Appendix A19 – TSC Pre-lodgement Meeting Minutes

Proposal: State Significant Development SSD-10398 for expansion of the Hanson's Sand Quarry (Phase 5 to 11).

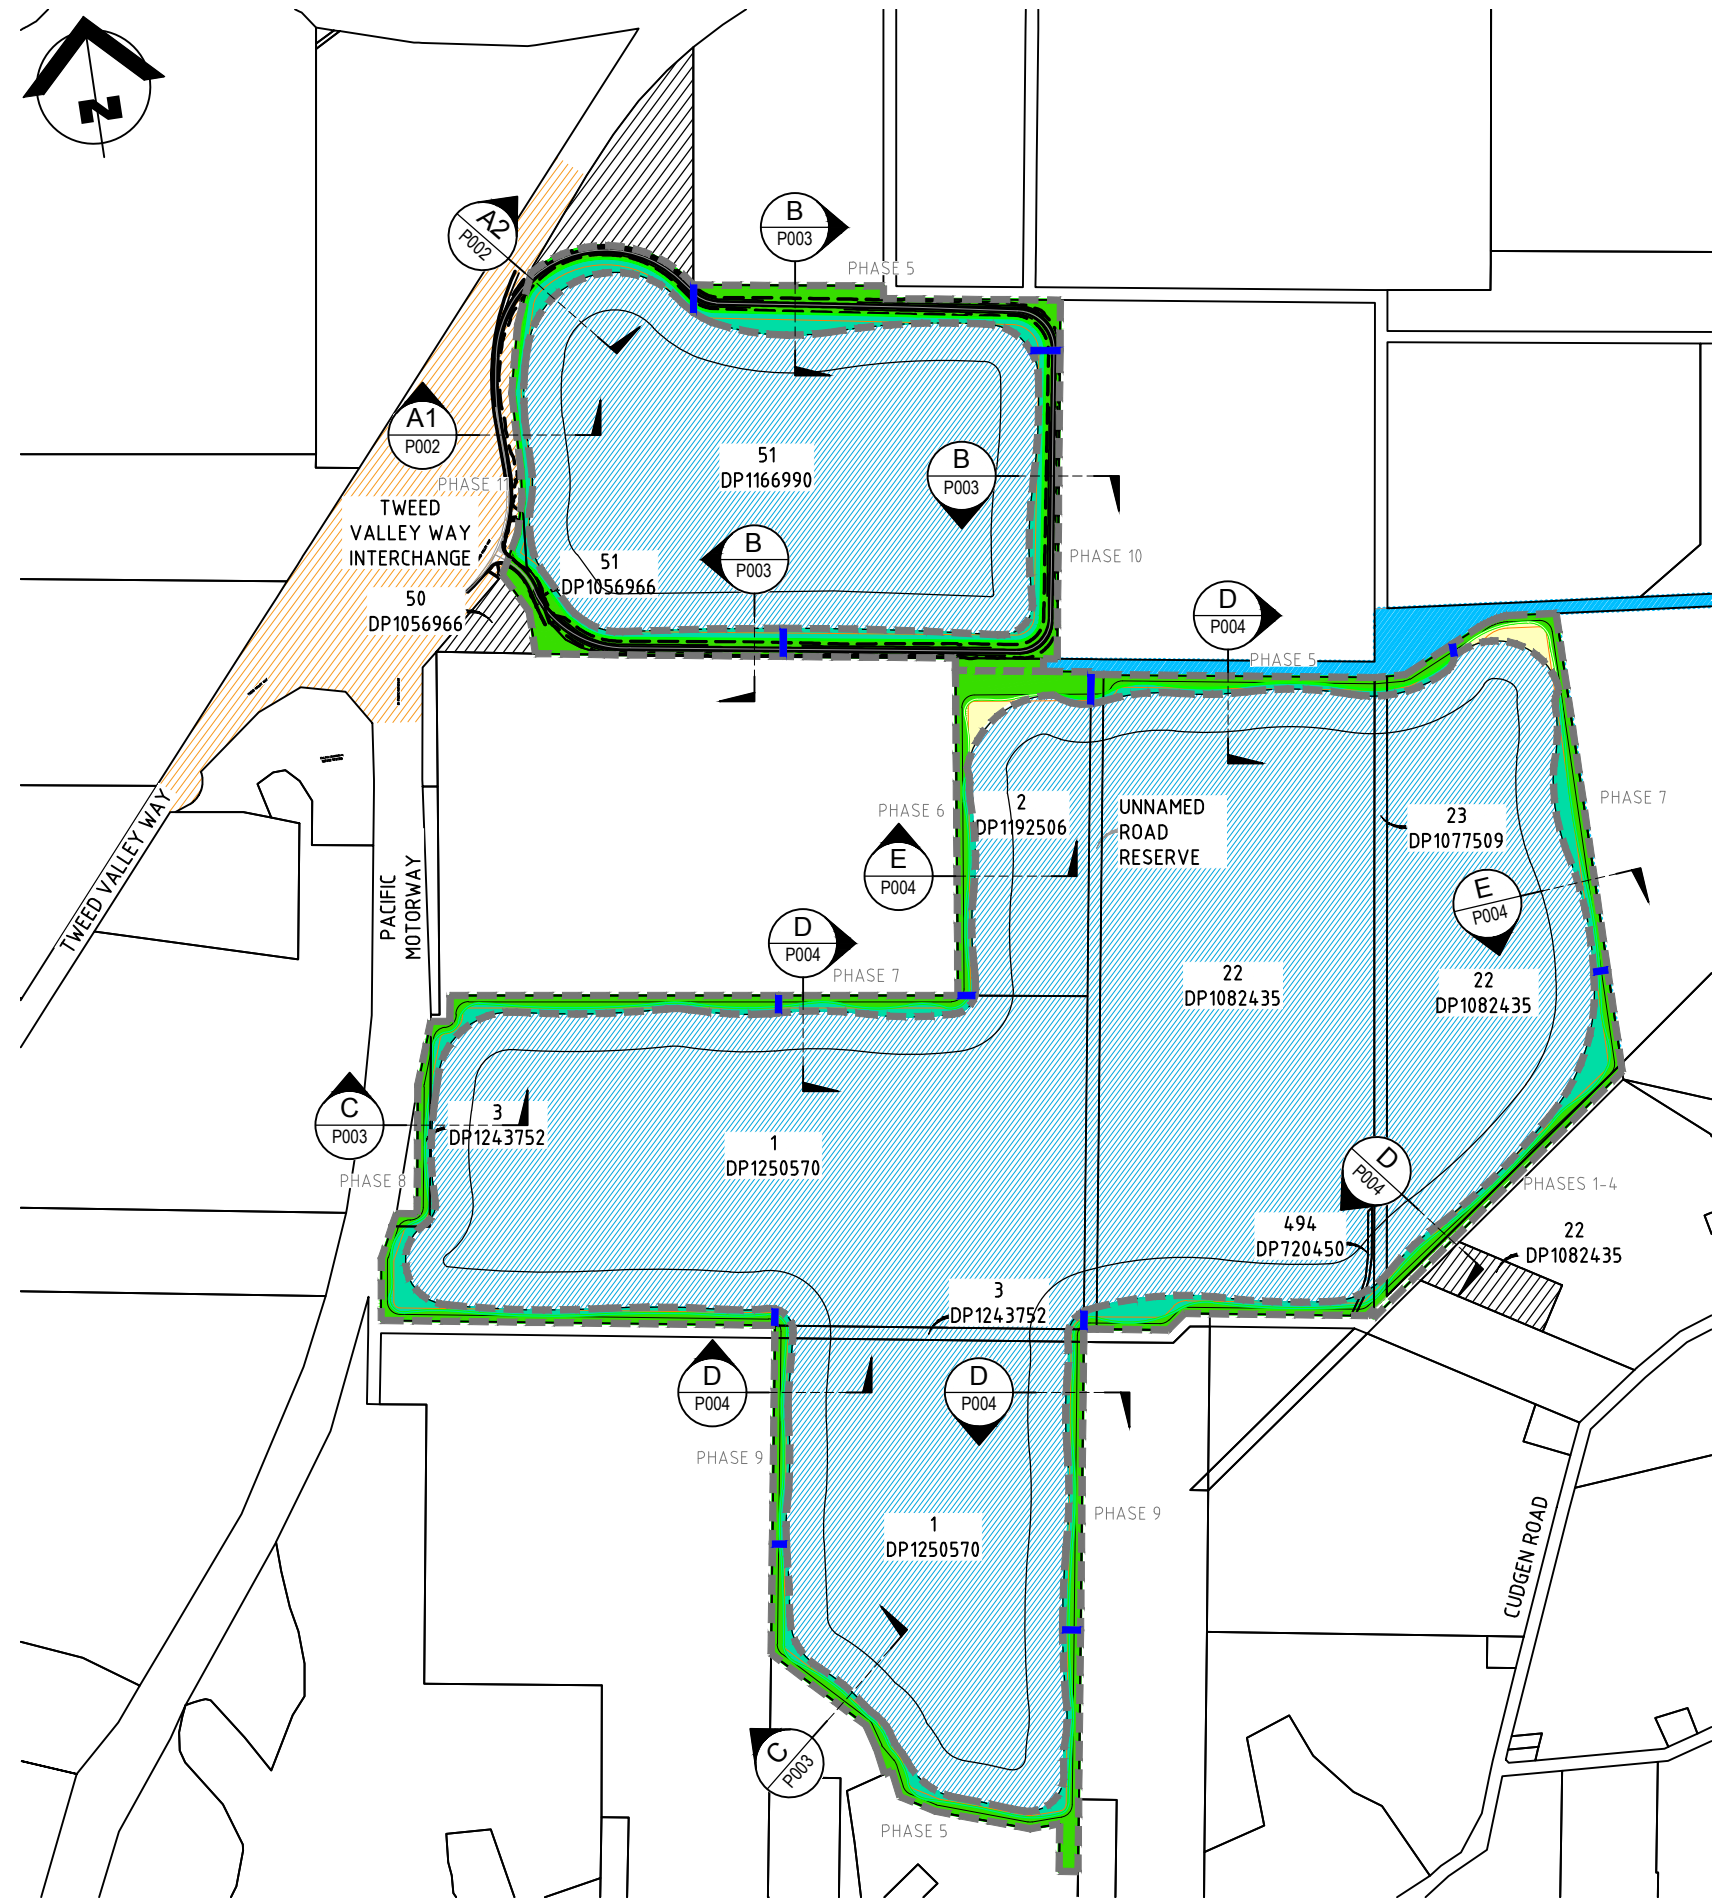
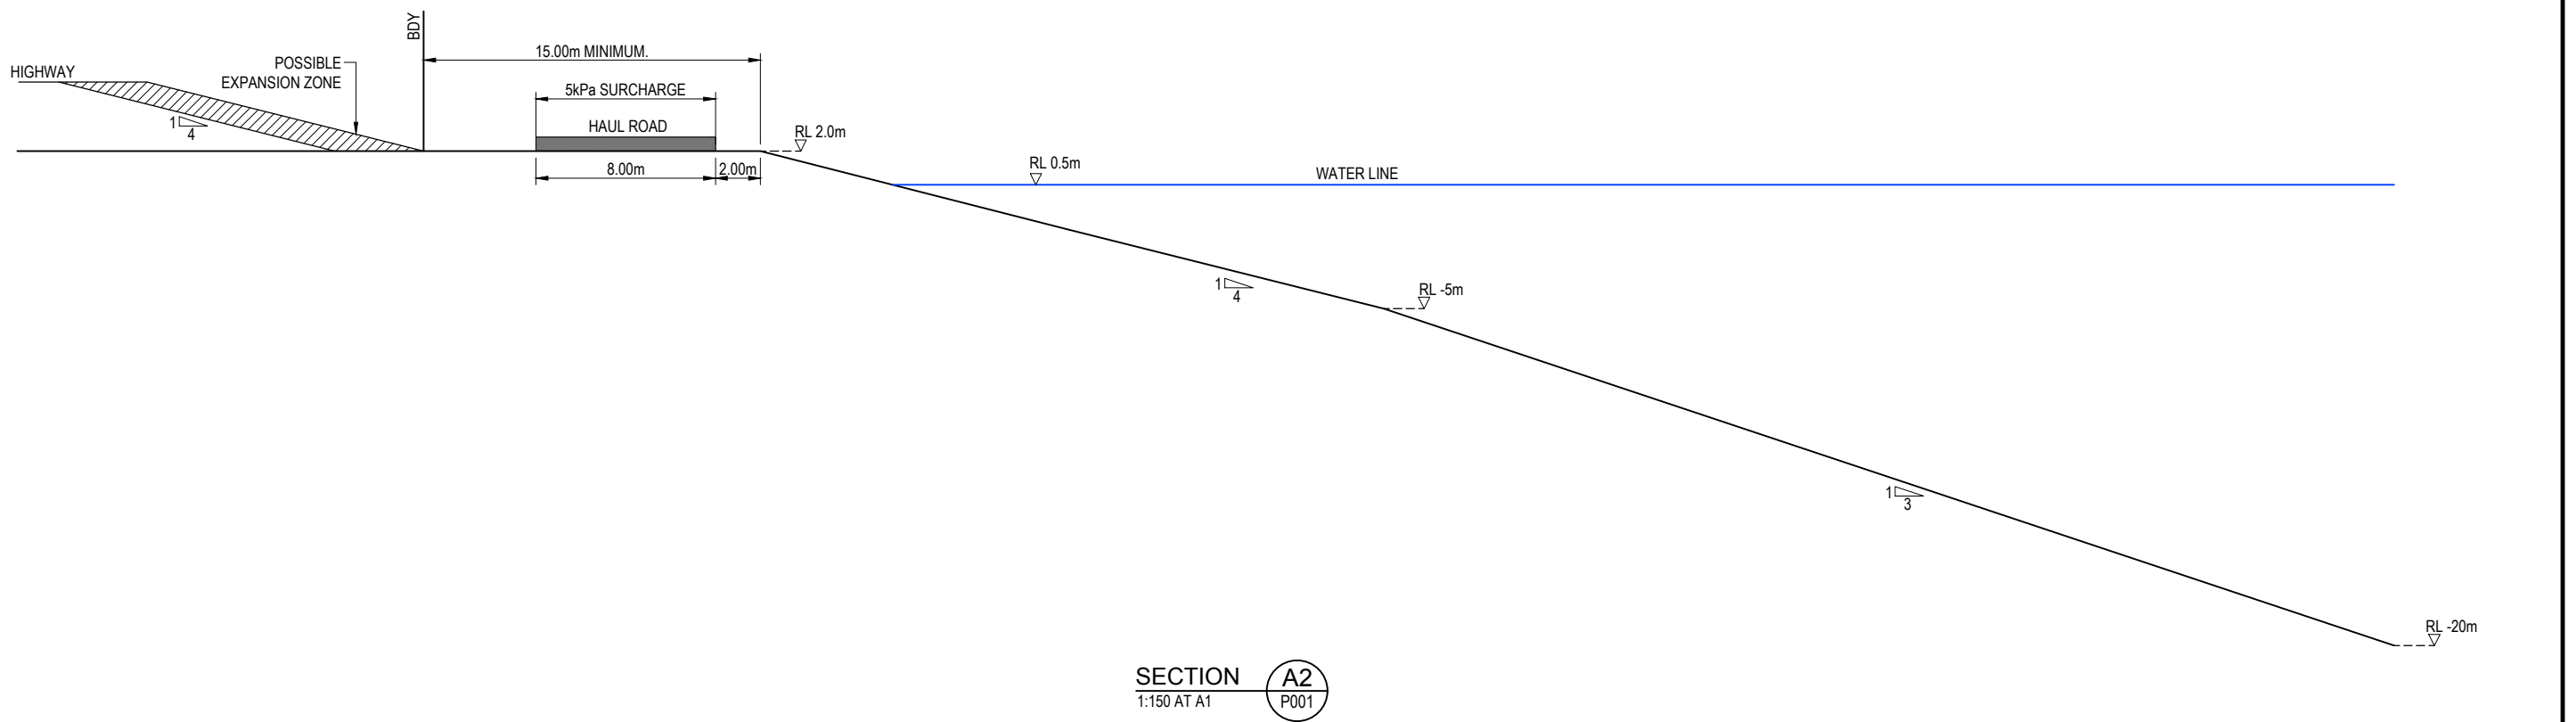
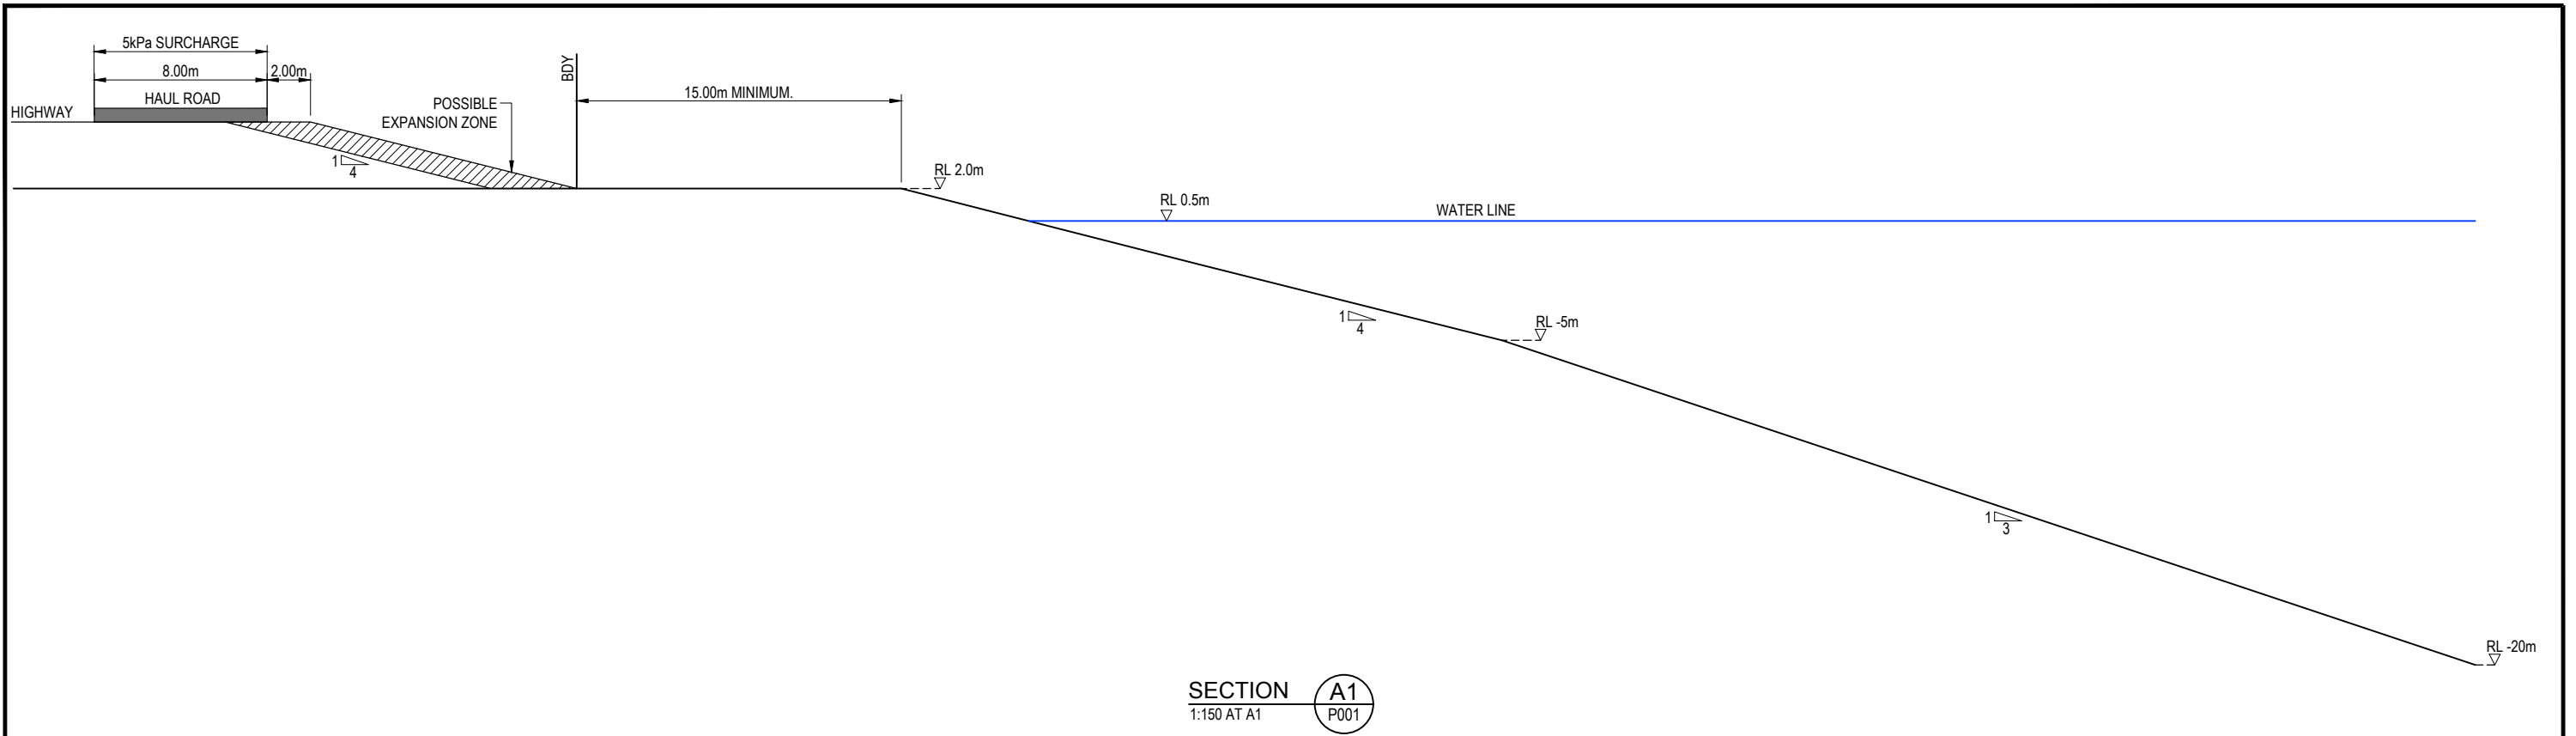
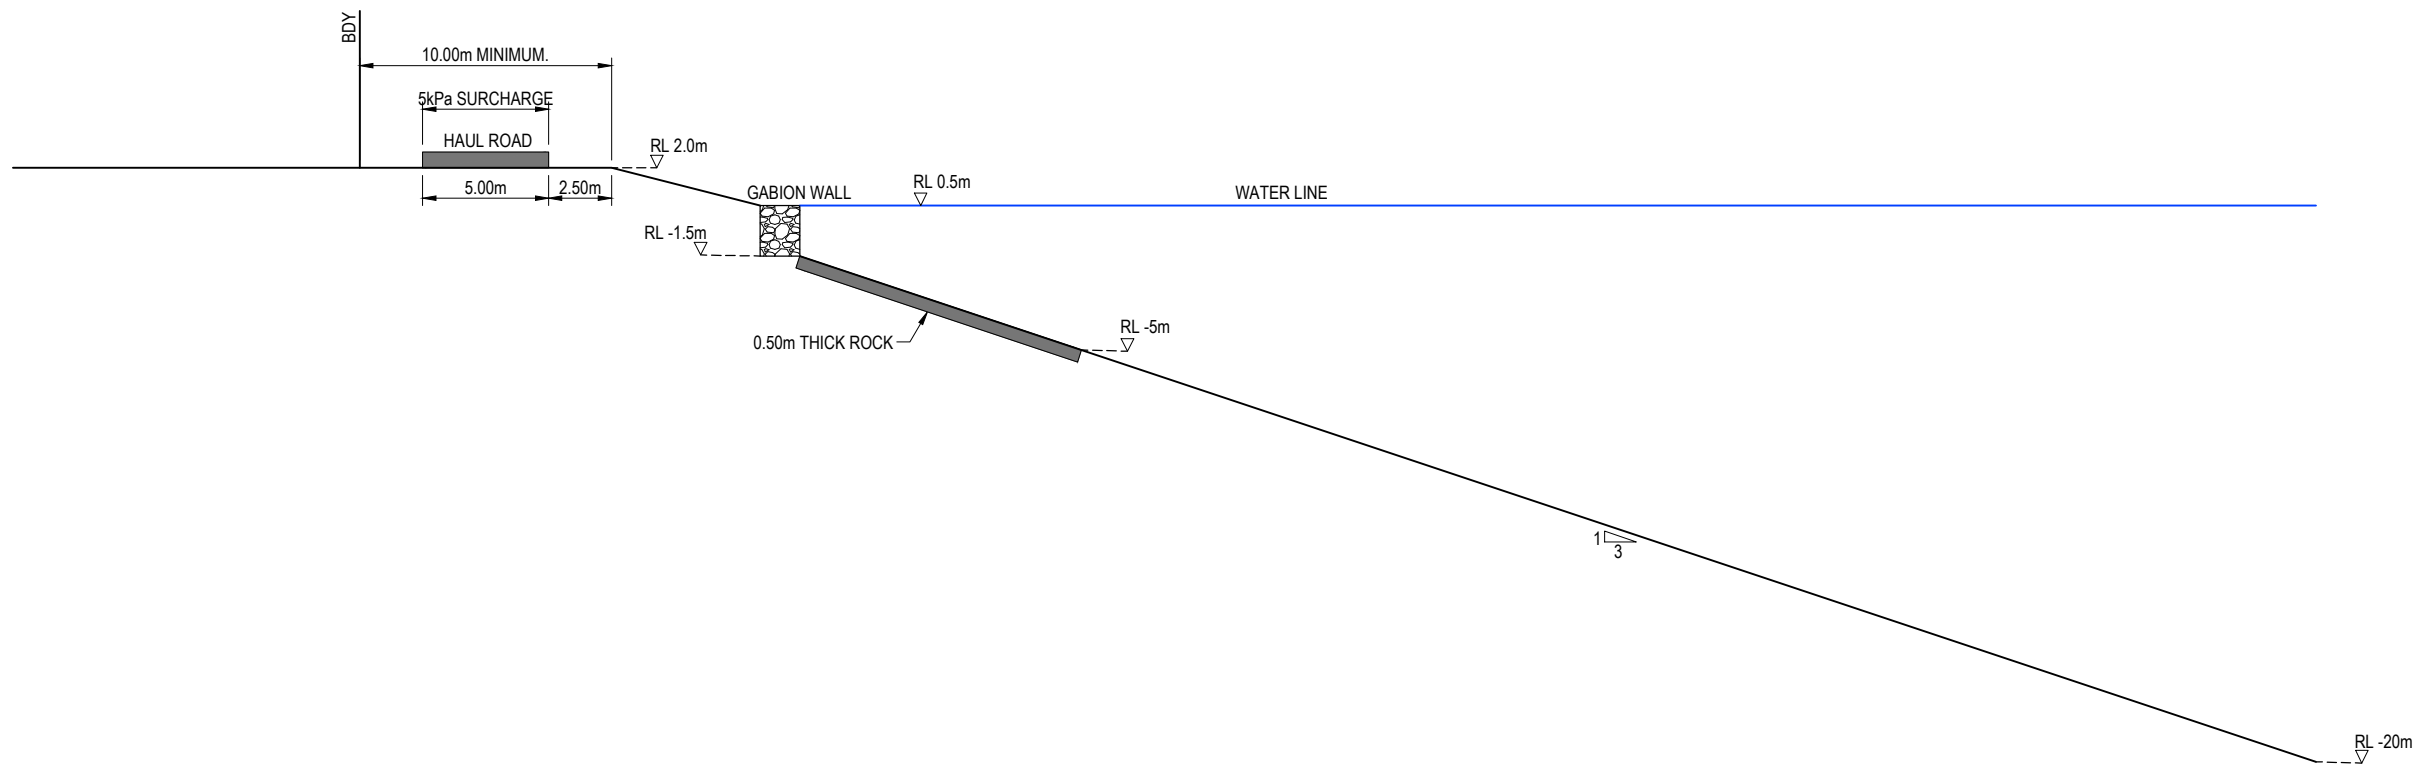
- The application should address geotechnical properties of the quarry site, including consideration of long term stability of the excavation batters, to ensure that they are designed and constructed to prevent slumping and instability on adjoining land in perpetuity.
